Our ref: DOC21/973453  
Senders ref: SSI-19238057

**Subject: EES comments on Environmental Impact Statement for Sydney Metro West Stage 2 Project – The Bays to Sydney CBD - SSI-19238057**

The Environment, Energy and Science Group (EES) has reviewed the following reports for this SSI:

Figure 18-2 Vegetation to be removed within and adjacent to the Hunter Street Station construction sites (Sydney CBD)

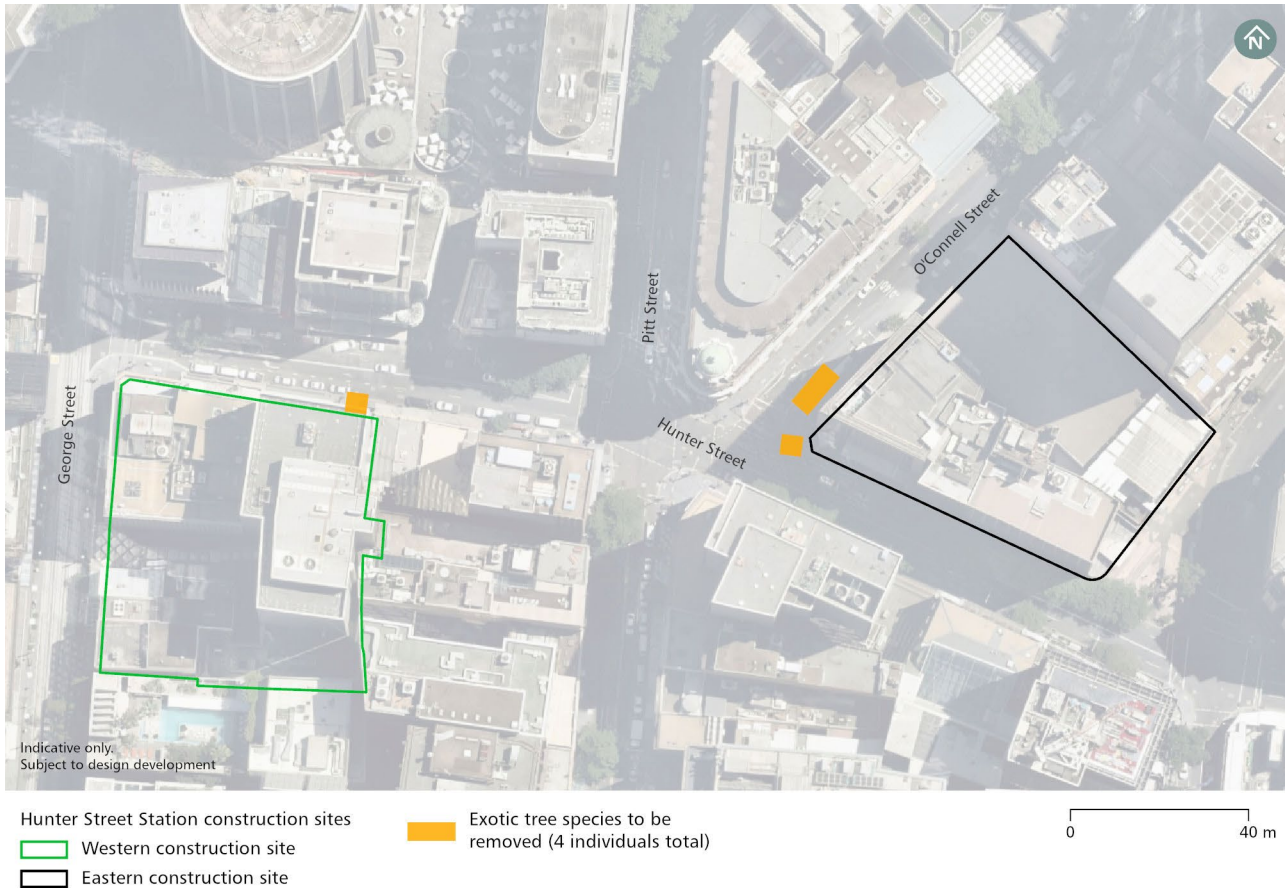
Section 18.1 of the EIS notes the proposal would result in the removal of around 16 trees (seven planted native trees and nine exotic trees) which includes six trees within the construction sites and ten street trees. The Executive Summary to the EIS and Section 18.1 state “mitigation measures have been proposed to further minimise or avoid potential biodiversity impacts, including pre-clearing surveys” (see pages xi and 18.1 respectively). No details are provided on the proposed pre-clearing surveys in Chapter 18 for Biodiversity.

Appendix C indicates a pre-clearing inspection will be undertaken “prior to any native vegetation clearing” by a suitably qualified ecologist (page 33). Exotic vegetation can also provide habitat for native fauna and it is recommended the pre-clearance inspections are conducted for all trees/vegetation (native and non-native) and other habitat features that have been approved for removal including any hollows, nests and dreys.

- ***Pre-clearance inspections to be conducted by a suitably qualified ecologist for all trees/vegetation and other habitat features that have been approved for removal. Any fauna captured will be relocated into areas of suitable habitat in proximity to the project site.***

Table 11.20 implies that the trees removed would be replaced to provide a net increase in the number of mature trees. It is suggested the RtS provides details on the number of replacement trees, the replacement planting locations, replacement plant species and pot size.
